In reply please quote: 16/09583
Your reference: SSD 7664

**PUBLIC EXHIBITION SSD 7664 - HORSLEY DRIVE BUSINESS PARK,
STAGE 2, WESTERN SYDNEY PARKLANDS, LOTS 18-24 IN DEPOSITED
PLAN 13961**

The following outlines Fairfield Council's submission in relation to the above matter as endorsed by Council's Outcomes Committee Meeting on the 14 February 2017.

DRAWING TITLE	
CONCEPT CIVIL WORKS PLAN SHEET 1	
DRAWING No	ISS
Co11492.11- DA41

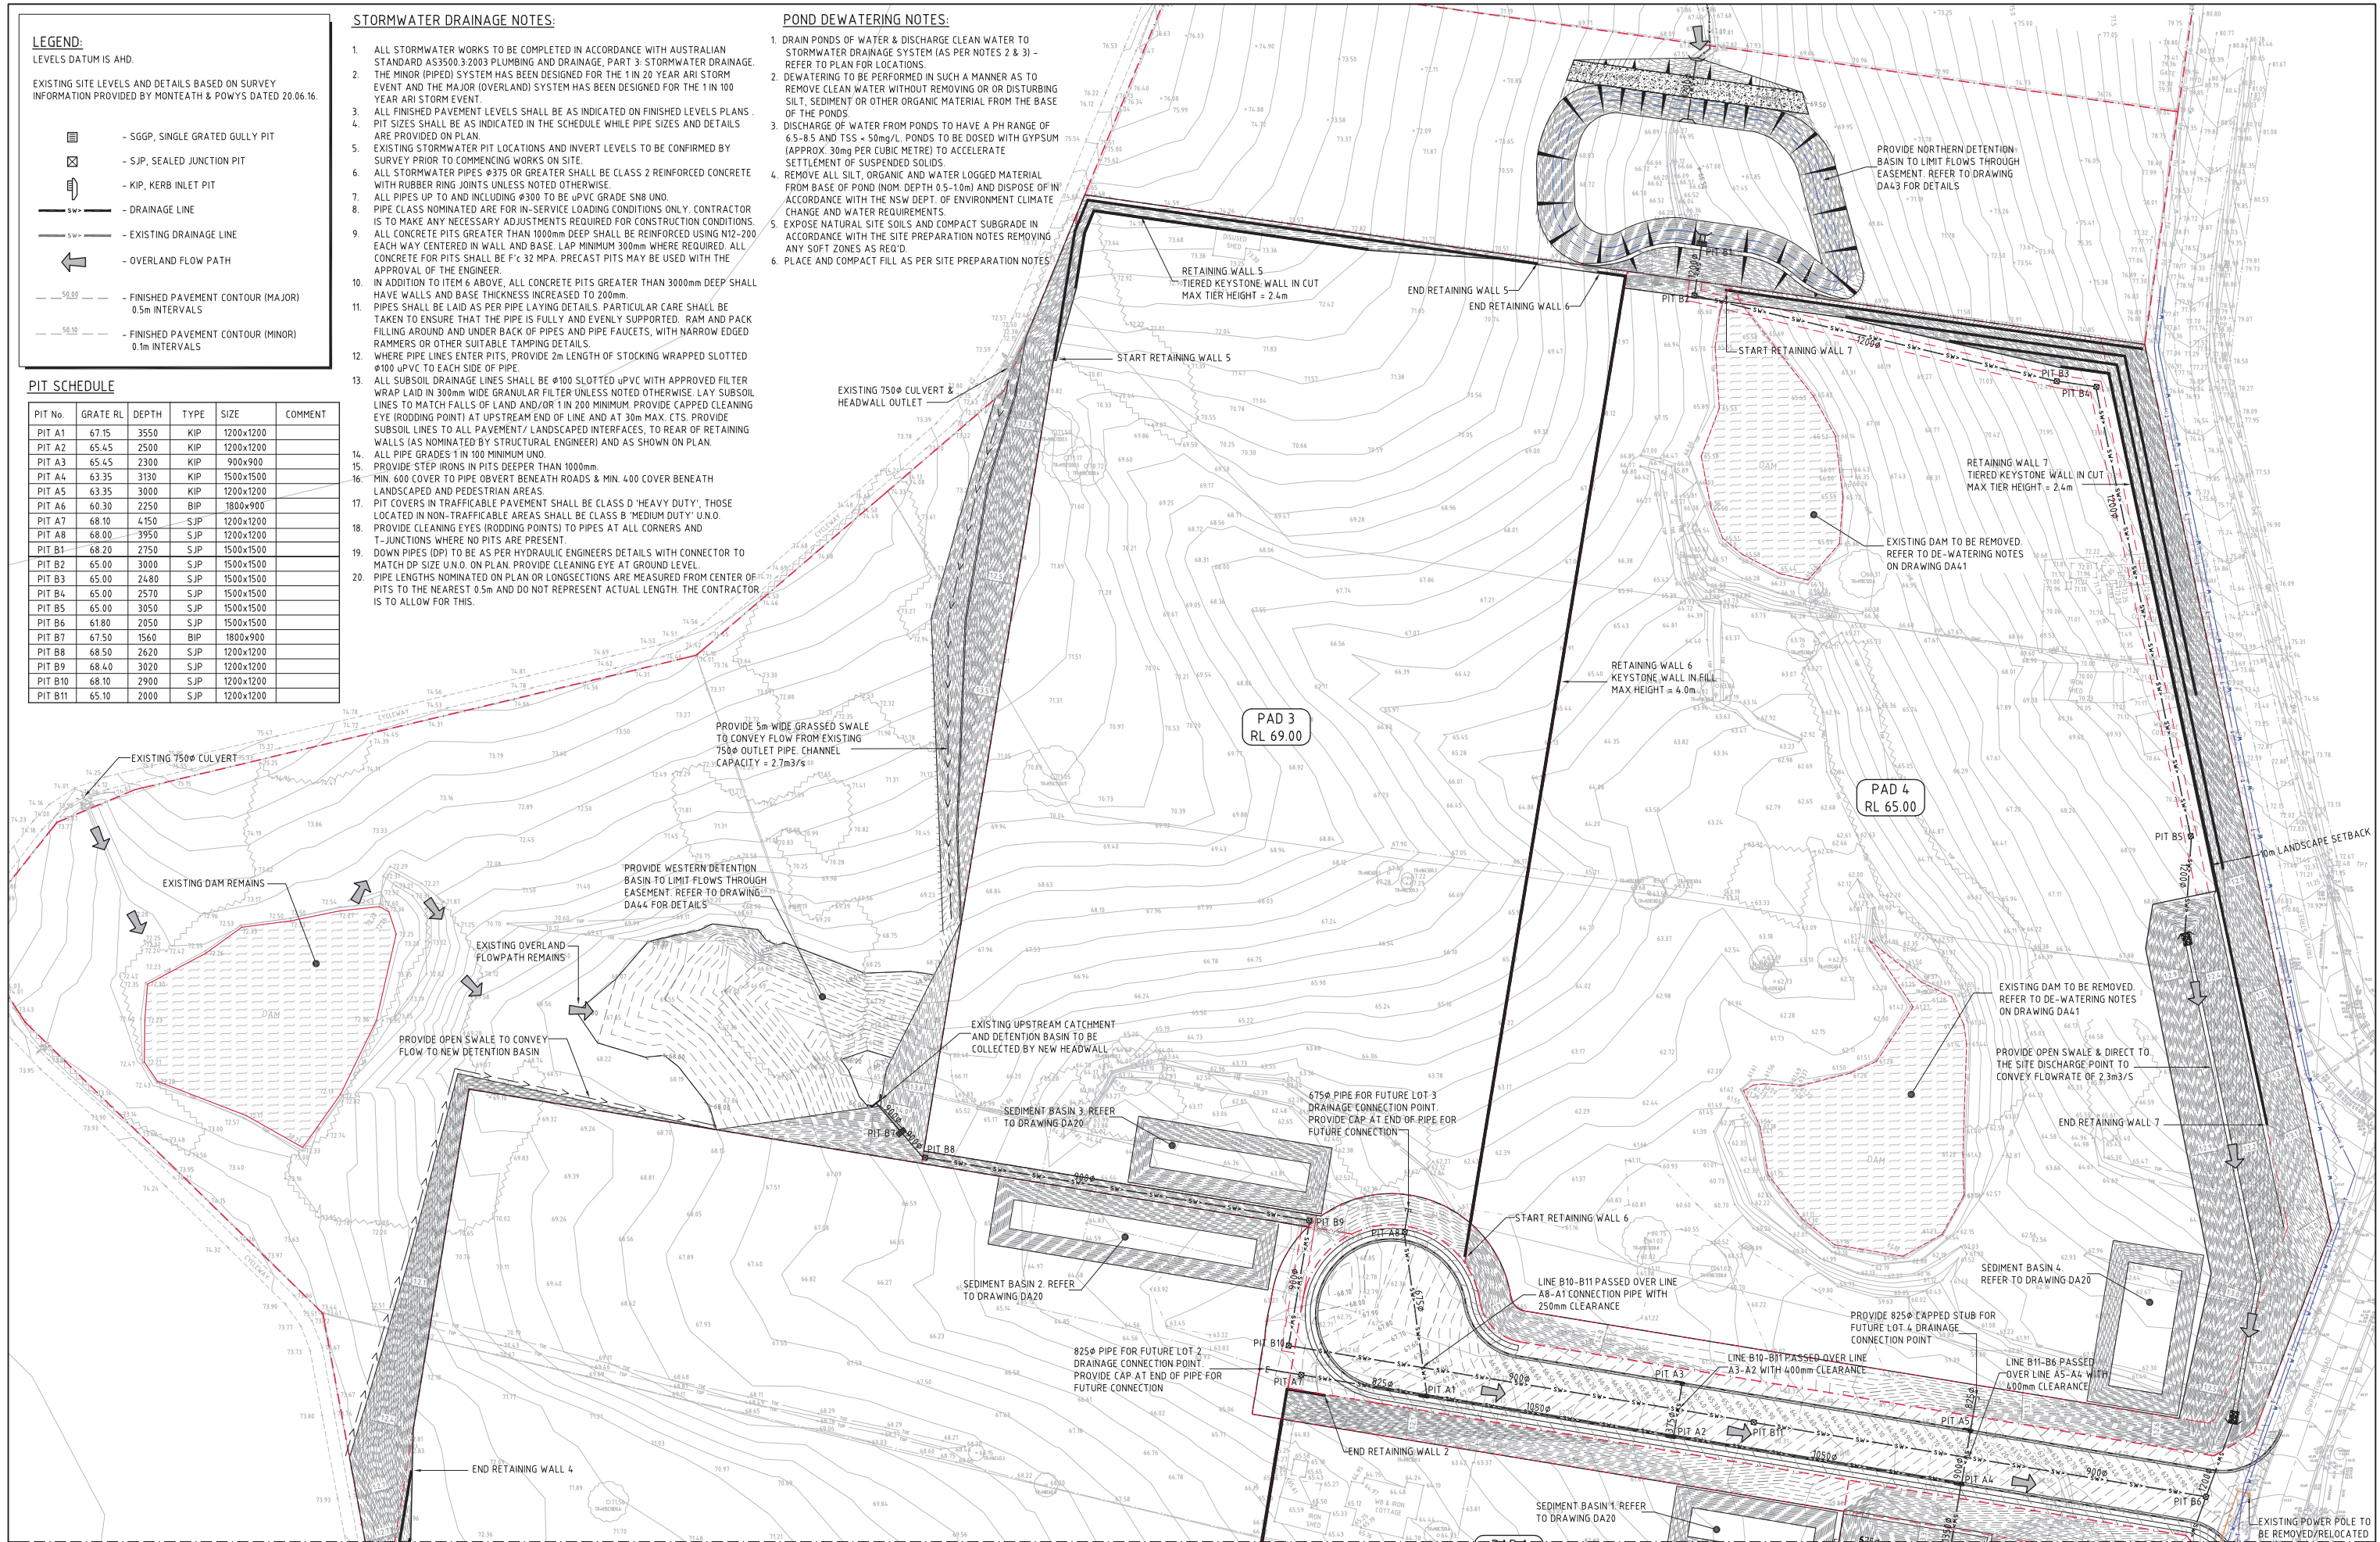
Both drawings Co11492.11 – DA41 & DA45 within the Civil Engineering Report show the southern drainage channel discharging freely to the existing swale. A stormwater outlet dissipater as per drawing Co11492.11 – DA46 should be constructed at this outlet.

7. Stormwater outlet dissipater to be added to southern drainage channel.
8. Details regarding channel capacity and rock sizing of southern drainage channel to be provided to ensure they are suitable and allow for approval.
